Application No: LU/144/20/HH
Site Address: 25 Windward Close Littlehampton BN17 6QX
Description of works: Detached single garage.

Thank you for your internet representation made on 15th July 2020 which has been recorded as an objection with the comments as follows:

proposed block plan

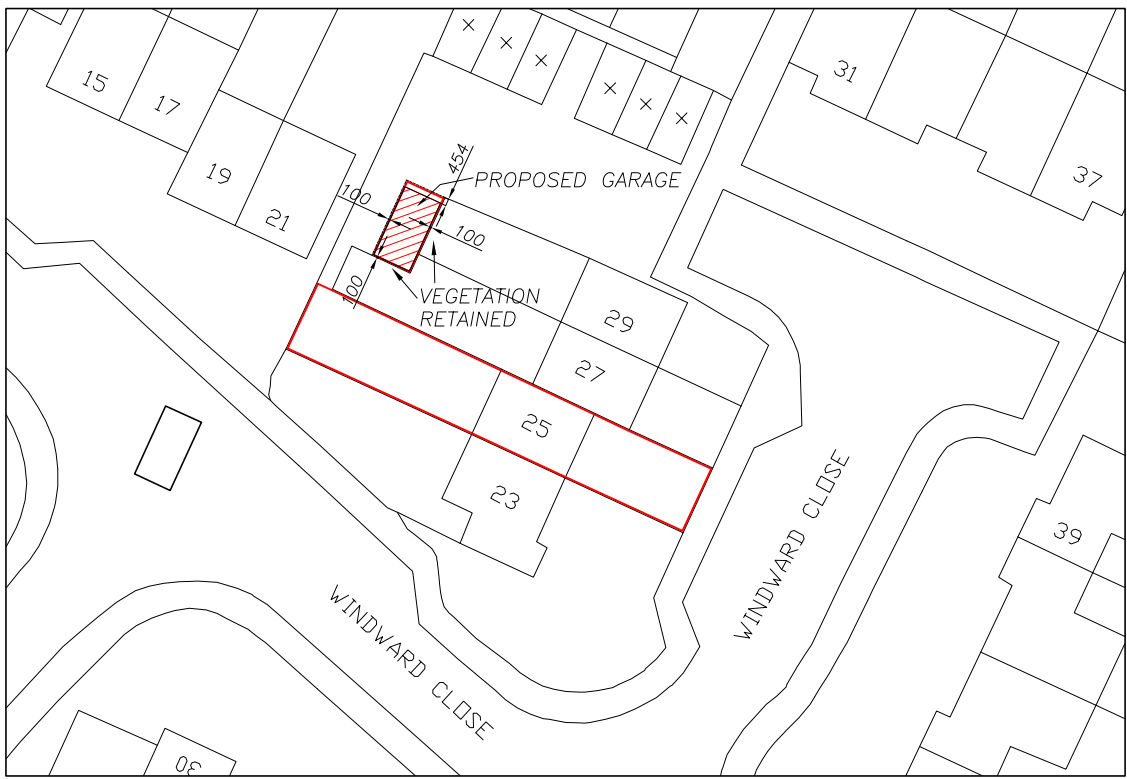
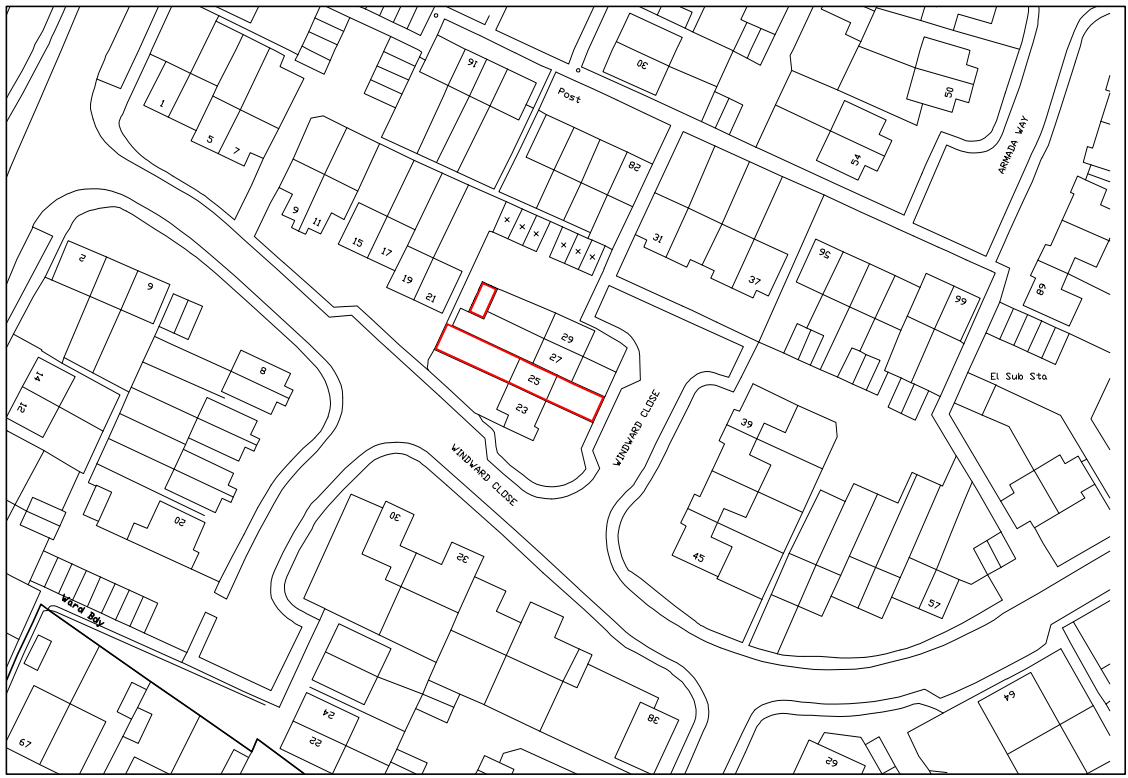
The proposed design and materials are in conflict with all other garages on the site and on the estate, which are in blocks with pitched roofs and pantiles. It would thereby be visually intrusive with a very prominent sloping metal roof. Nobody has so far been permitted to build on a parking space on the estate. In addition myself and no 29 would be unable to access our fencing from the outside for maintenance. Trees would need to be removed from inside to gain access should fencing collapse against the garage. In short the proposal is overdevelopment, and there is not enough room on a single 1979 standard size parking space. It cannot be known what were the intentions of the developers, but they did not build any single garages on the estate, and in this case did not transfer land sufficient for that purpose.
